Subject: Pagham discharge of conditions Arun P/87/19/DOC and Chichester SY/19/02257/DOC

P/87/19/DOC - Approval of details reserved by conditions of P/97/15/PL for Conds 4, 5 Tern Island Compensation, 6, 7 proposed mitigation measures to protect Little Tern habitat, 8, 9 and 14 at Church North Spit Pagham Harbour Pagham.

SY/19/02257/DOC Discharge of Conditions 1 to 14 of planning permission SY/15/03053/FULEIA. Address: Managed Breach, Pagham Harbour, West Sussex,

Fig 5 – Profile and elevation of finished little tern compensatory nesting habitat (metres ODN) on the ‘concrete revetment’ spit, Pagham Harbour

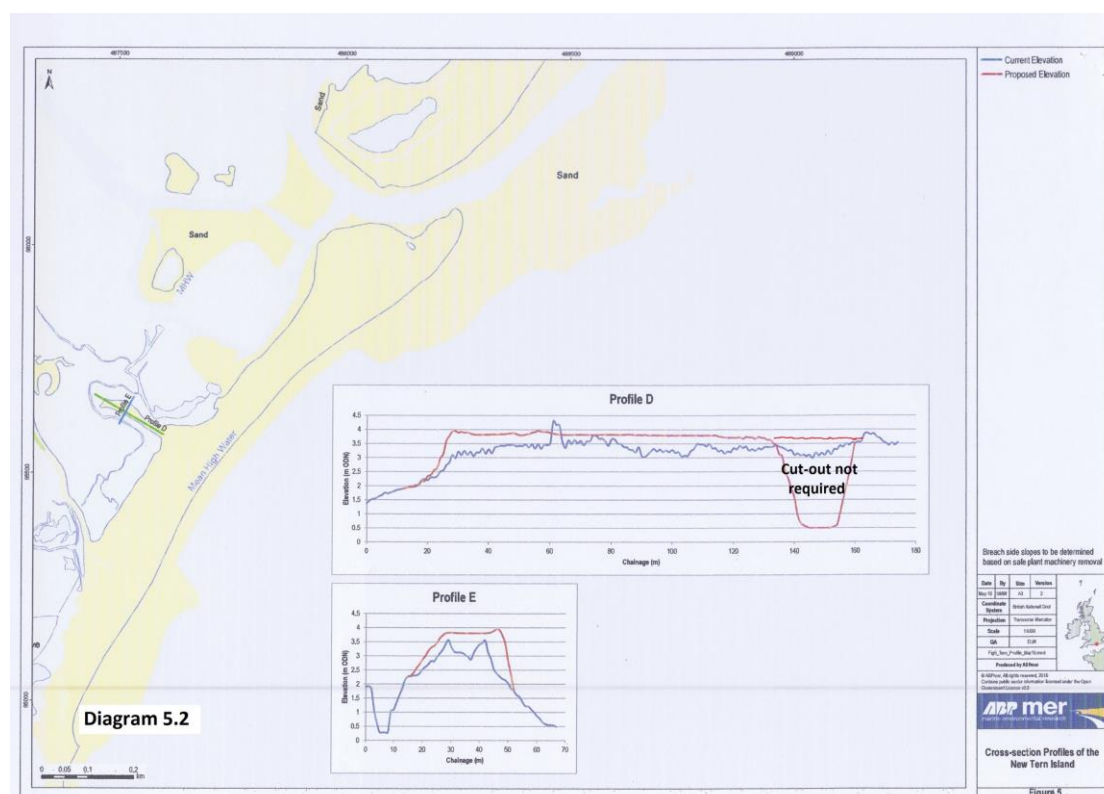
More detail is required regarding the design and management plan of the compensation habitat due to both amendments that are proposed and lack of information to comply with conditions 5 and 8.

With regard to the compensation habitat no longer being an island as proposed in the original application and whether this new design meets the same requirements as originally agreed this needs to be demonstrated.

Consideration needs to be given regarding any increase in disturbance from people and dogs that the habitat may now experience due to greater accessibility. The improved predator fencing is welcomed and will exclude direct access on the habitat, however, the connection with land and the closer proximity may deter little terns from nesting on part of the habitat.

We understand tern chicks go beyond the fencing on the current island and therefore being attached to the main spit would make them more vulnerable.

Consideration should also be given to the little terns generally nesting by the water edge and whether this new design reduces this opportunity.
